***The Planning Act 2008 - Chapter 2 Examination TR010025
A303 Amesbury to Berwick Down Improvements***

***Written Submission by the Council for British Archaeology
and CBA Wessex***

***Supplementary Observations Regarding
Highways England's Responses to Examination Questions:
Cultural Heritage***

AG03 Winterbourne Stoke West barrows and the Coniger Enclosure

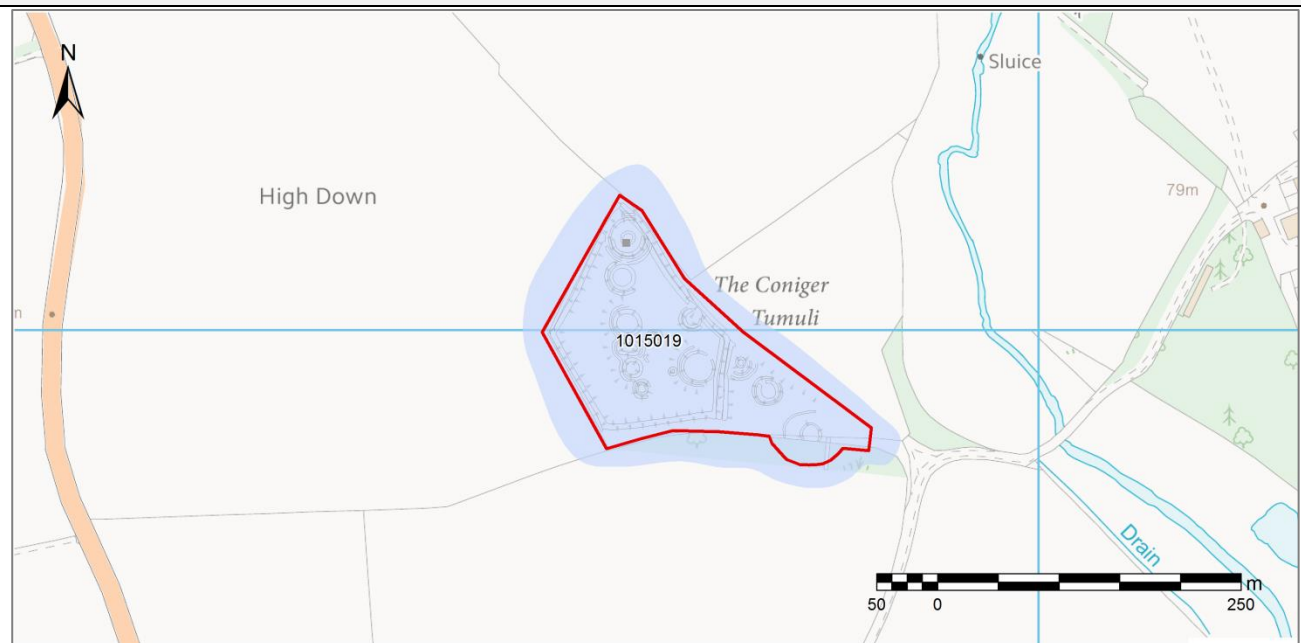
Question CH.1.41 (Sequential Experience of Setting of AG03 and AG04: Winterbourne Stoke Barrows)

The question relates to a key aspect of the WHS OUV, which concerns the relationship of monuments to the landscape and the setting of the WHS and how its OUV can be experienced from beyond its boundary. As we have previously commented the ES and HIA have systematically under recognised and/or downplayed these considerations. HE's response is another example of the dismissive approach taken to this key aspect of the how the relationship of monuments to topographical position is experienced moving through the landscape.

AG09 Oatlands Hill

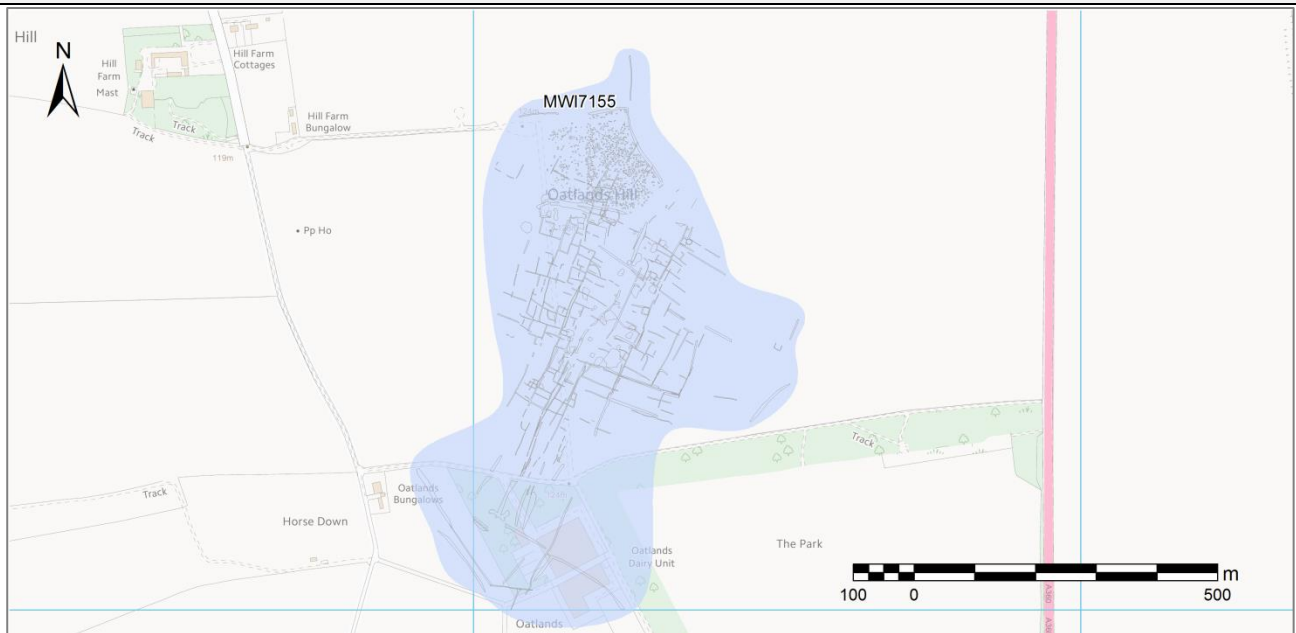
Question CH.1.6 (significant archaeological remains to be disturbed by the new Longbarrow junction)

The response provided only covers the Oatlands Hill 'C-shaped enclosure' raising a number of issues. The statement, *the enclosure does not contribute to the OUV of the WHS, being of Late Bronze Age*

date reflects a fundamental problem that the ES and HIA reflect which is a far too narrow view of what contributes to the OUV of the WHS. This does NOT reflect what the adopted Management Plan says about the WHS being important for prehistory generally (not just Neolithic and earlier Bronze Age ceremonial and funerary monuments); nor the importance of what came after or what went before the main period of constructing monuments. While later written evidence of subsequent values is explicitly cited as part of the area's OUV the late prehistoric and Roman periods for which we are reliant on archaeological evidence is also part of this issue.

AG13 The Diamond Group

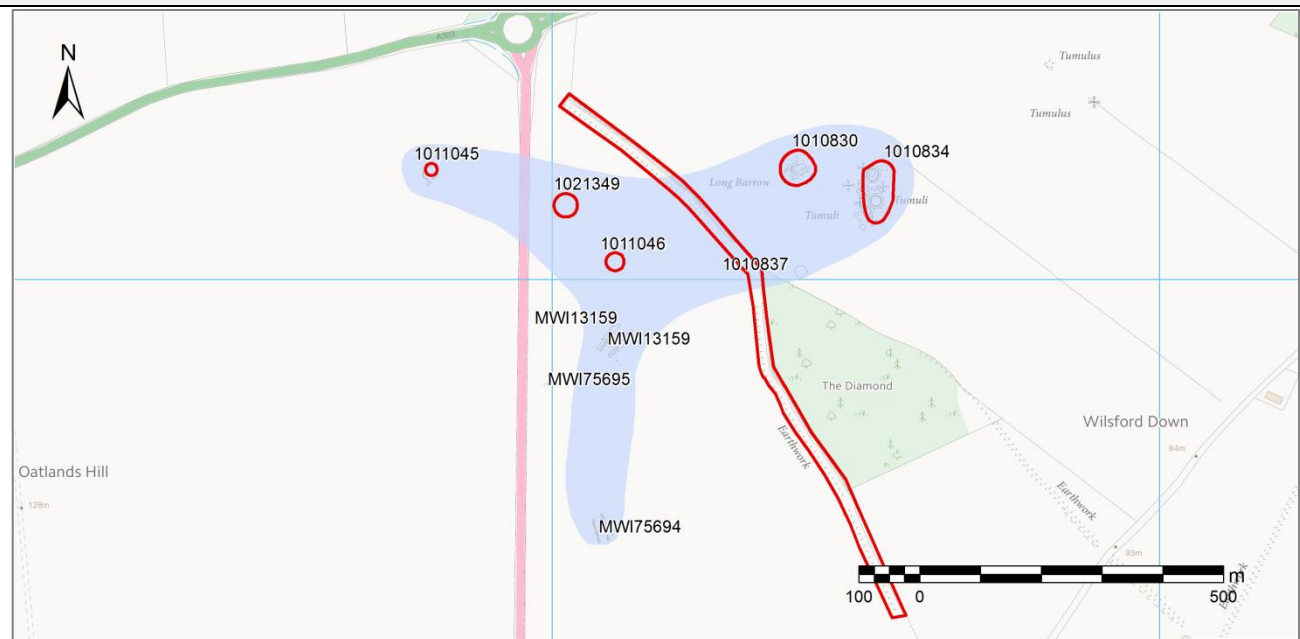
Question CH.1.42 (AG13: The Diamond Group Severance of Linear Earthwork)

It is clear that this feature would be severed and that it is part of a designated monument: it is large and well-preserved below ground. The loss of a 60m length of a major prehistoric boundary of national importance is not trivial. The assessment of its being a 'minor' impact after mitigation is irrelevant to the planning balance, since that must be carried out **without** taking account of the ability to record remains that would be lost. It should also be noted that according to the mitigation strategy between 60% and 80% of the affected length would NOT be excavated (cf REP2a-005). Given the size of the ditch this is a significant amount of deposit to be lost without record.

AG27 The Avenue

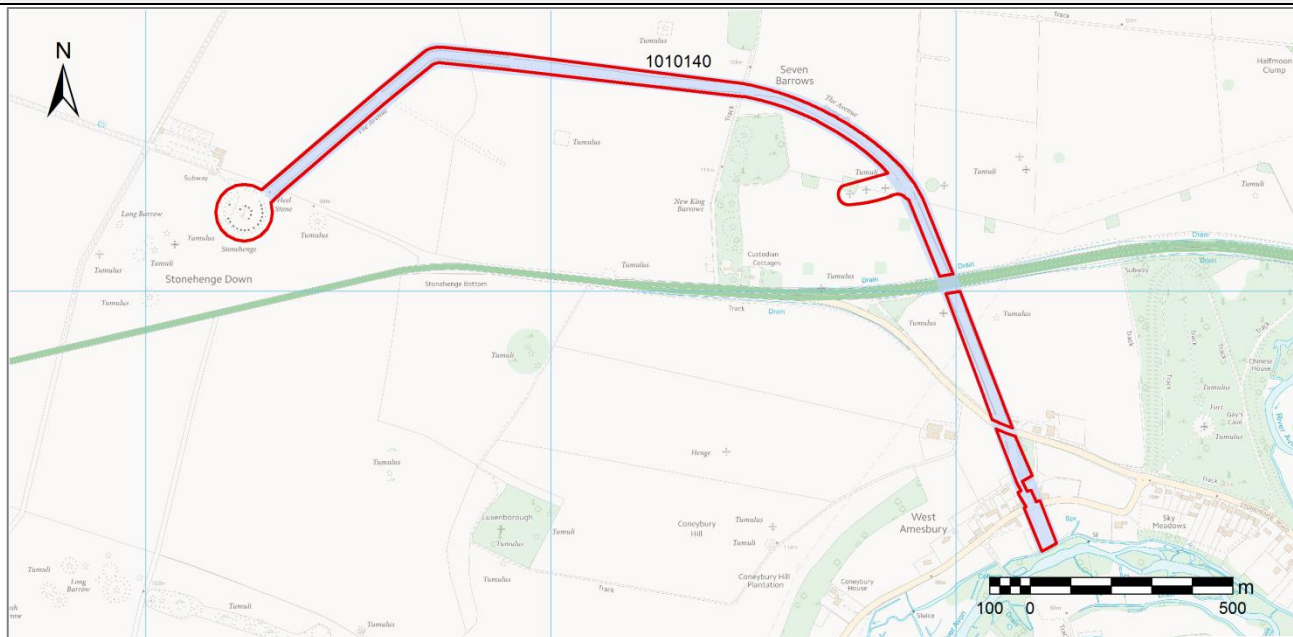
Question CH.1.44 (Treatment of the Avenue)

The statement that the Avenue would be unaffected by the scheme is patently wrong. Its being grassed over (and potentially readily marked out by mowing, or even by partial restoration of or replication of its banks) would mean that it could (in principle) be better experienced in terms of following its course; but this would be at least partially offset by the excavation of a substantial cutting and creation of the E tunnel portal in the side of the ridge not far from it. This impact on its setting and how that would be experienced (another case of the OUV relationship between monuments and the landscape) has not been identified or assessed.
